June 30, 2015

CBL: 020 D013001 (020-D-13-14-15-32)
Located At: 101-121 Newbury St, and 40-46 Hancock St
RE: Complaint # 30300/ Partial Lifting of Stop Work Order

3 June 2015
File No. 42222-000

Subject: Utility Work in Newbury and Federal Streets
Seaport Lofts Project

OFF-SITE DRAINAGE PLAN
 OF: SEAPORT LOFTS
 NEWBURY/HANCOCK STREET
 PORTLAND, MAINE
 FOR: 113 NEWBURY STREET, LLC
 35 FAY STREET, SUITE 107B
 BOSTON, MA 02118-4320

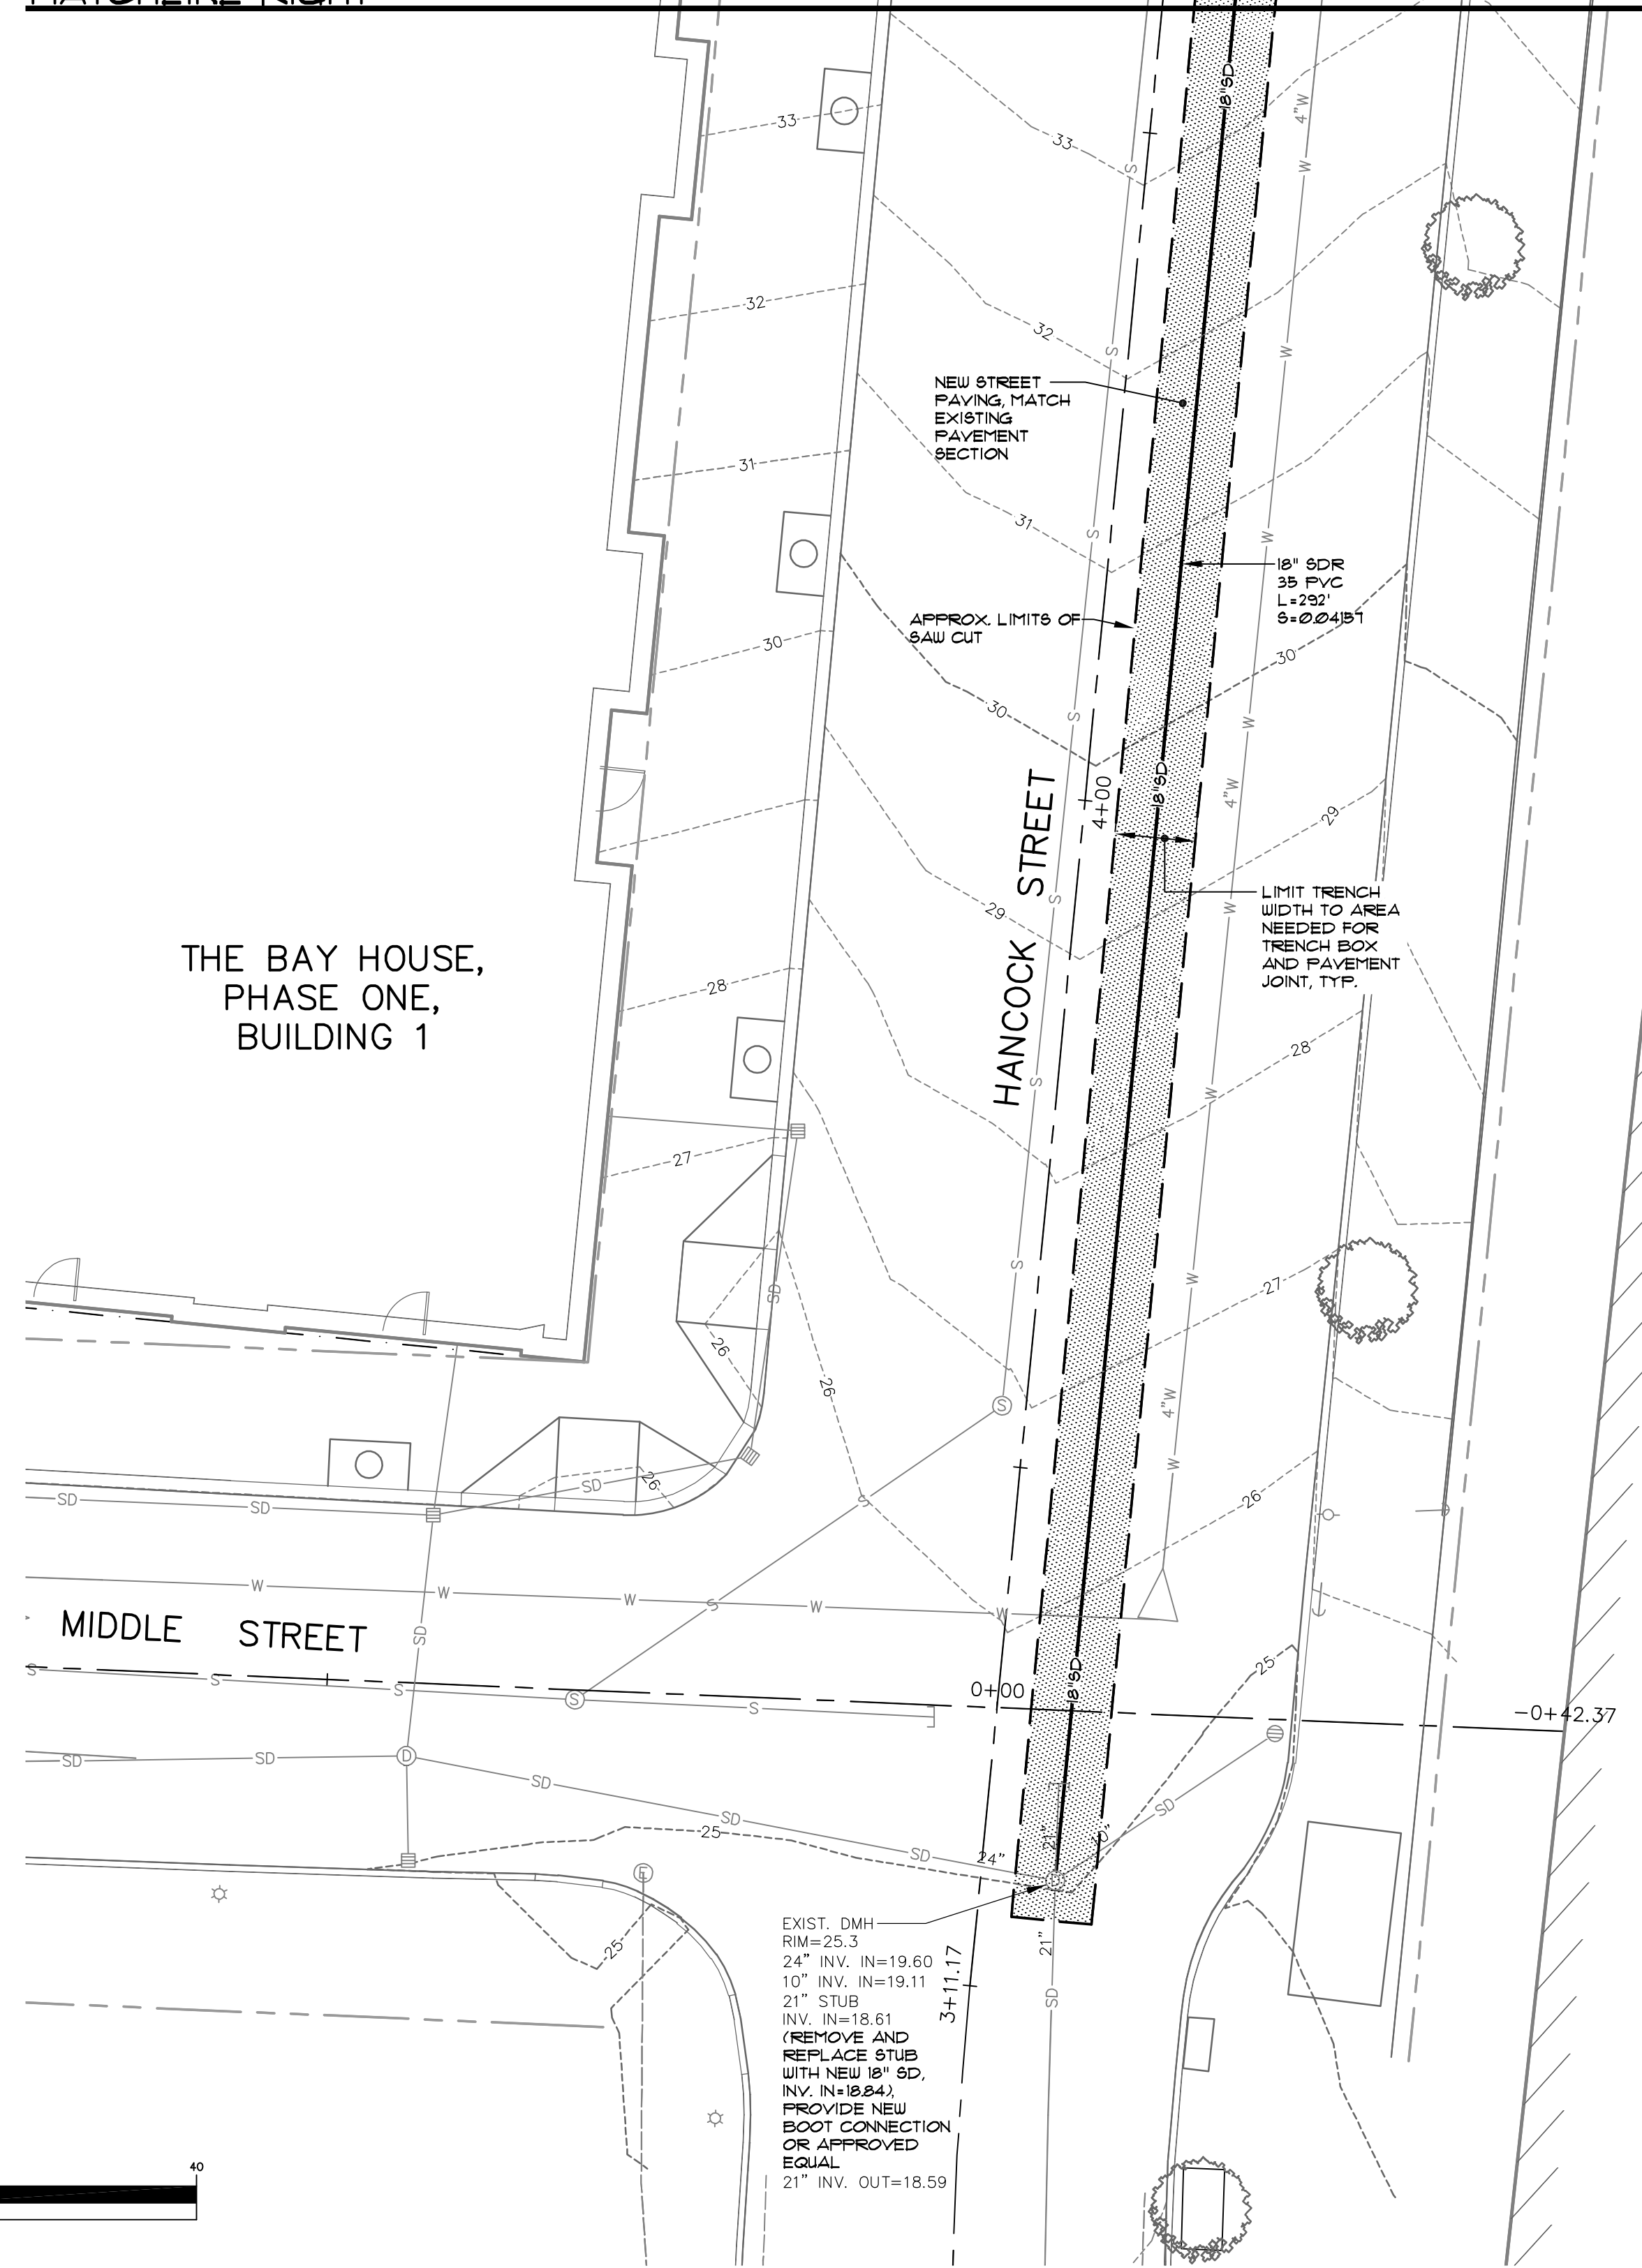
Per discussions with you during our 2 June 2015 site visit, our discussions with RWLR, and our review of the Sebago Technics, Inc. (STI) plans entitled "Grading and Utility Plans, Sheets 4 and 5," it is our understanding that the scope of the new utility work that is proposed is as follows:

- **New Storm Drain Lines:** A new, 18-in. dia., approximately 280-ft long storm drain line will run north from the existing drain manhole at the intersection of Middle and Hancock Street to a new manhole (DMH) DMH-3 at the intersection of Hancock and Newbury Street. From DMH-3 a new, 15-in. dia., approximately 220-ft long storm drain line will run west along Newbury Street to new DMH-1 located near the new entrance to the development. From DMH-1 a new, 15-in. dia., approximately 30-ft long storm drain line will run northwest to new catch basin (CB) CB-2 at the southeast corner of the project site. It is our understanding that CB-2 was previously installed just inside the site boundaries. Associated DMH structures will also be installed as part of this work (i.e., DMH-1, DMH-2 and DMH-3). Based on invert in/out information provided on the STI plans, we estimate that the excavation depth needed to install storm drain lines and manholes will range from approximately 7 to 15 ft (relative to existing site grades).

- **New Foundation Drain:** A new, 6-in. dia., 15-ft long foundation drain located will run from the southwest corner of Unit 17 to new DMH-1 in Newbury Street. Based on invert in/out information provided on the STI plans, we estimate that the excavation depth needed to install this drain line will be approximately 8 ft (relative to existing site grades).

- **New Potable Water Line Stubs:** Two new, 4 and 6-in. dia., approximately 35-ft long water line stubs will run from the southeast corner of Unit 15 to the existing 8-in. dia. water line in Newbury Street. We estimate that the excavation depth needed to install the water line stubs will range from approximately 5 to 6 ft (relative to existing site grades).

- New Sanitary Sewer Stub – A new, 6-in. dia., approximately 30-ft long sanitary sewer stub will run from the Entry/Vestibule to the existing 12-in. dia. sanitary sewer line in Newbury Street. Based on invert information provided on the STI plans, we estimate that the excavation depth needed to install the sewer stub will range from approximately 5 to 8 ft (relative to existing site grades).

Based on the STI plans referenced above, the utility excavations will be 80 ft or more (in plan) from the new retaining walls along the north side of the project site, 100 ft or more from the existing retaining wall adjacent to the blue house at the northeast corner of the site, 105 ft or more from the existing blue house at the northeast corner of the site, and 150 ft or more from the Federal Street Townhouses located north of the site. Based on discussions with you, it is our understanding that the excavations will be supported using trench boxes. It is also our understanding that the trenches will be excavated, the utilities installed, and the trenches backfilled in a sequenced manner such that only short lengths of trench excavations will be open at any one time.

Based on the scope of the utility work, the location of the work relative to the structures on the north side of the site, and the planned means and methods of utility installation, it is our opinion that the installation of the new utility lines in Hancock and Newbury Streets can be safely completed without causing additional movement of the new site retaining wall and the existing adjacent structures north and northeast of the site. As a precaution, we recommend that the established survey points be surveyed prior to, during and after the utility work to confirm that no additional movement has occurred.
